Application no: H16-0064-11

Description: Details of first floor window to side elevations, external materials, window frames and external doors, eaves and verges, rainwater goods, meter boxes, frontage wall, finished ground and floor levels and archaeological report (Conditions 2, 3, 6, 7, 10-13, 15-17 of H16-0687-10)

Location: 45 Cowbit Road
Spalding
Lincs
PE11 2RH

Amendment: Eaves detailing (dwg. no. 1916-05D)

Drg Title: **Elevations**

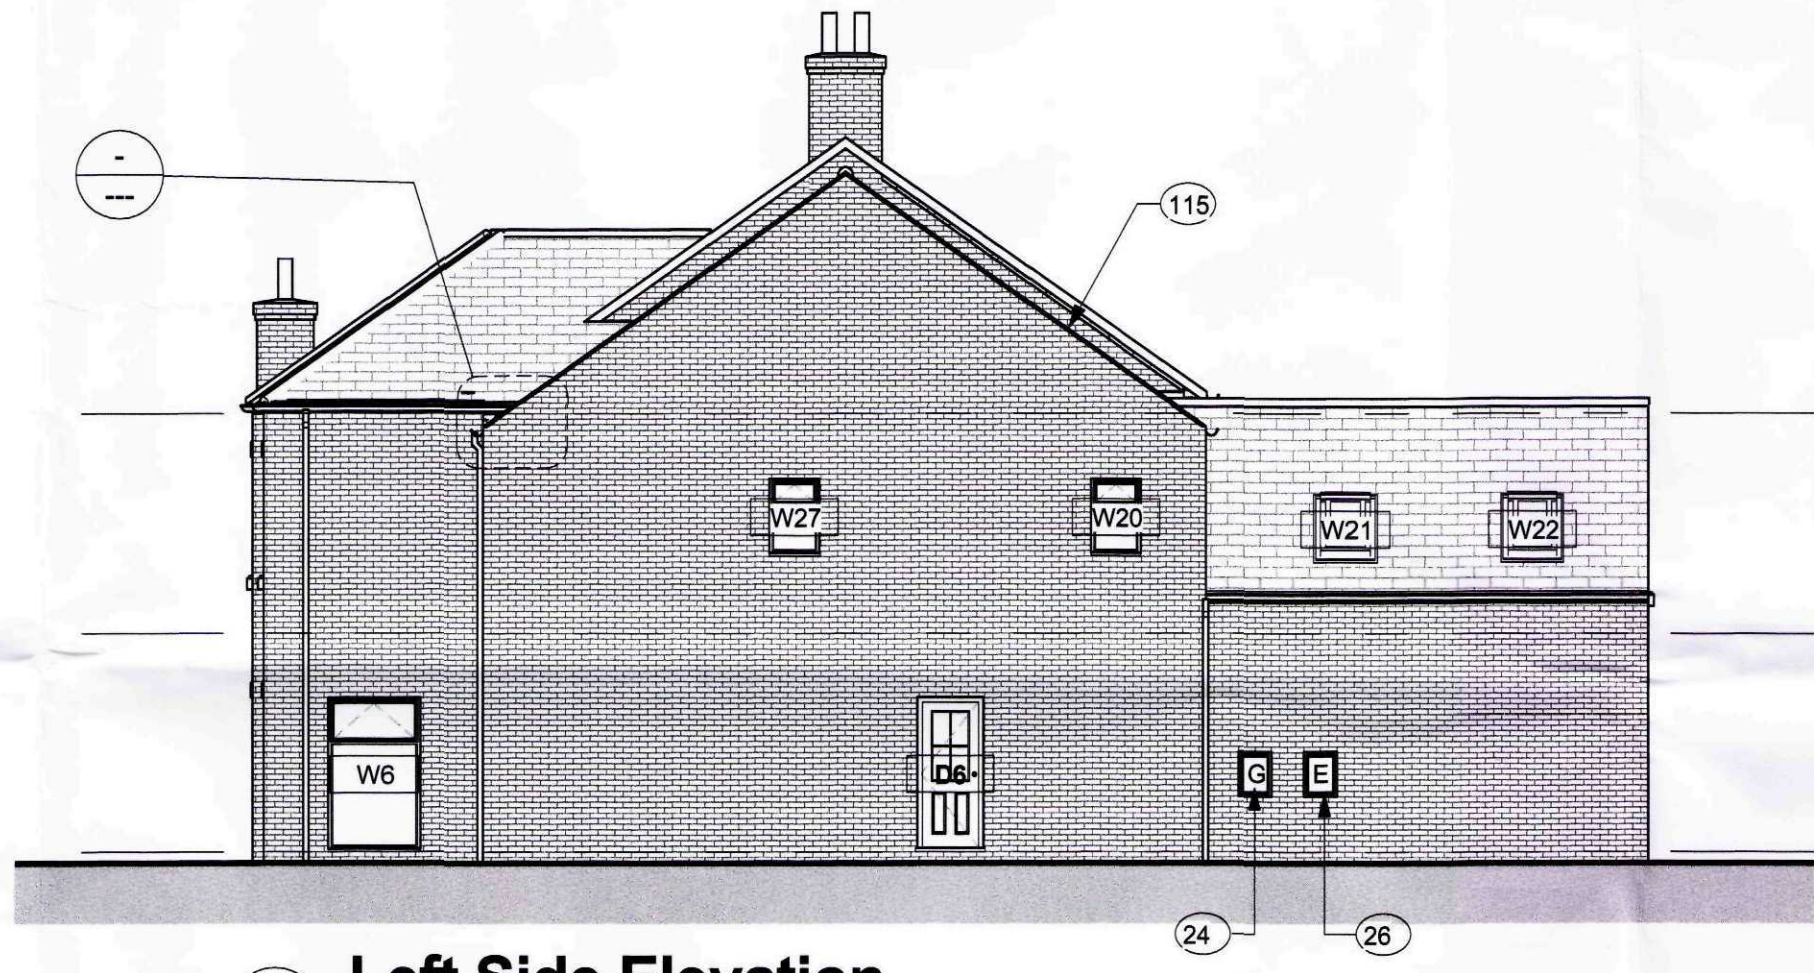
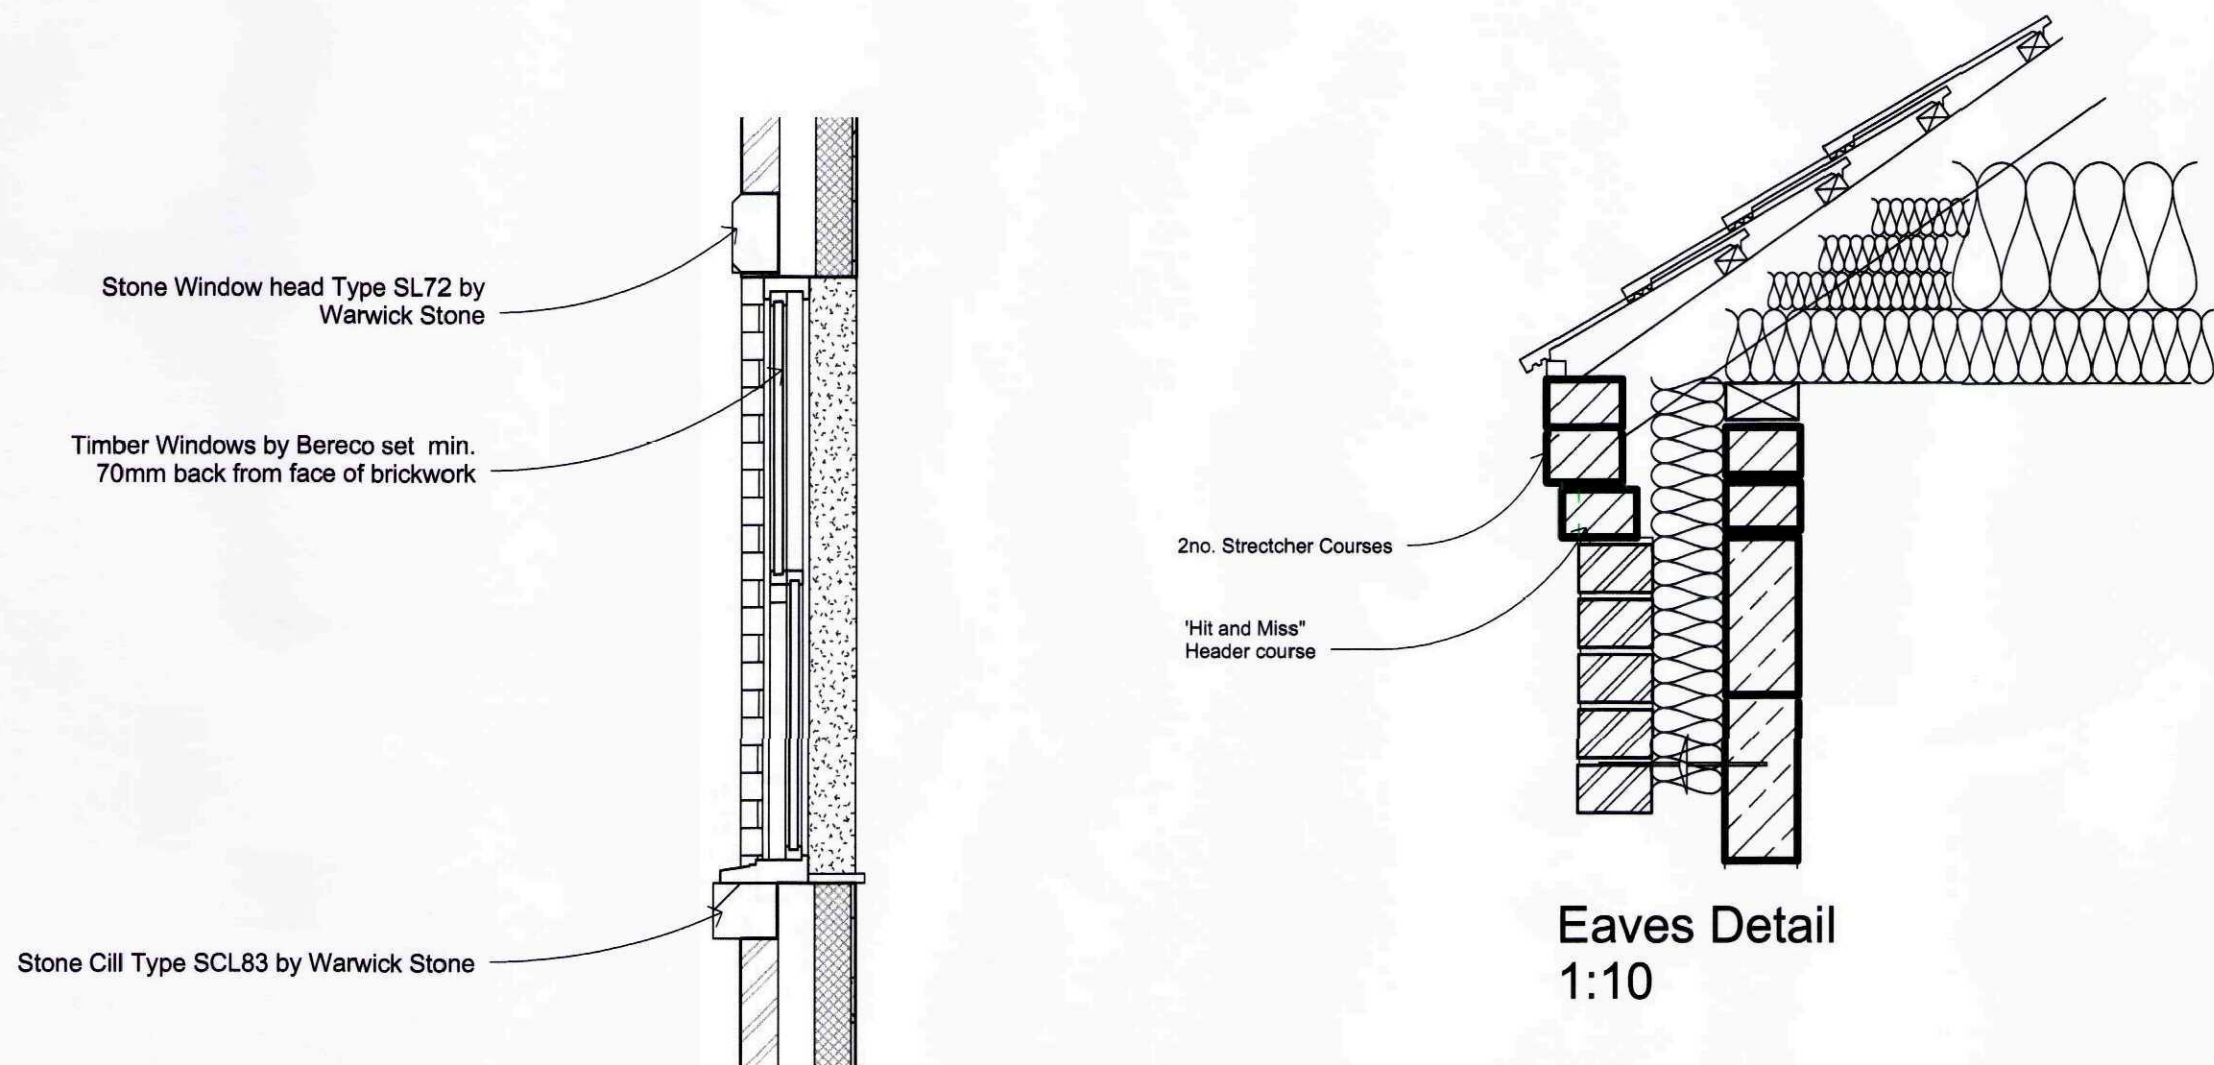
In respect of eaves detailing, this will need to be brick corbelling or a brick dentil course. I therefore look forward to receipt of revised plans that address this matter.

We attach amended drawing showing requested Eaves Detail.
